From: Liz Rogers [REDACTED]
Sent: 09 April 2018 15:39
To: Planning.Responses
Subject: RE: Planning Consultation on: A/36/18/OUT

App No: A/36/18/OUT

Address: Land off Arundel Road Angmering BN16 4ET

Proposal: Outline planning application with some matters reserved for the erection of up to 200 dwellings with access, public open space, landscaping and sustainable drainage system (SuDS) with vehicular access point from Arundel Road, one full-sized adult football pitch and the demolition of industrial units and one residential dwelling. Departure from the Development Plan.

Plate 9. B3 from the east

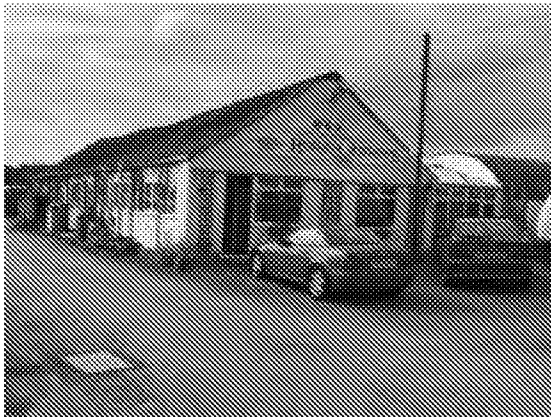
Though some emergence surveys have been undertaken on building B1 on the site, the other buildings which were identified as having bat roosting potential B2, B3, B4, B13 have not been surveyed. Though further surveys have been recommended for these buildings prior to demolition we require that they are undertaken prior to determination. The survey needs to be undertaken by a suitably qualified ecologist during the active breeding period (May – September) and submitted for our approval with the planning application.. If bats are found to be roosting within the building mitigation will be required and a mitigation strategy should be produced and also submitted with the planning application prior to determination.
